Mark E. Jones, PE  
Structural Engineering and Design

Ref: Site Inspection and Analysis  
Attached Garage  
265 Hook Dr.  
Fuquay-Varina, NC  
Permit No. SFD2305-0108  
Project No. 24-054

**S-1**  
GARAGE REMODEL  
STRUCTURAL PLANS

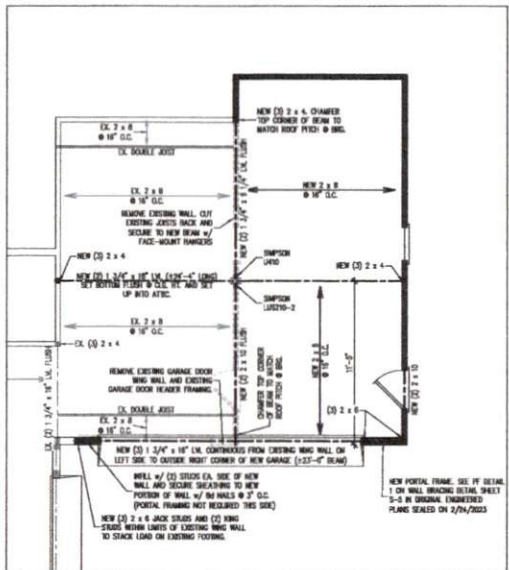
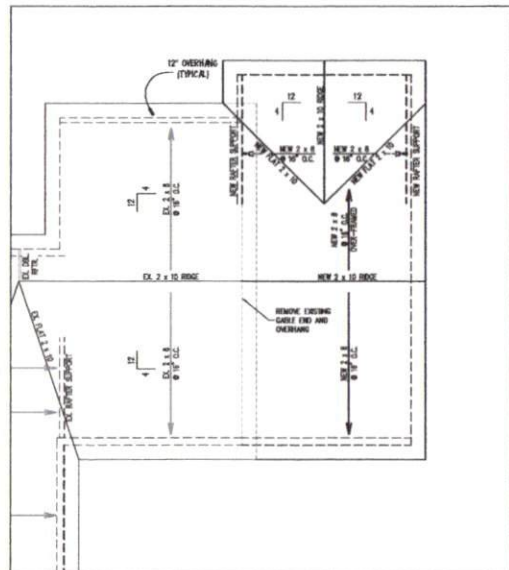
1. No projection at the beginning of new wing wall.

1. The end of the foundation wall at the garage door opening sits flush with the edge of the footing. As the garage door header shall be portal framed, the load bearing will be distributed inside the face of the wall/footing. The existing construction will adequately support all imposed loads. No action is required.
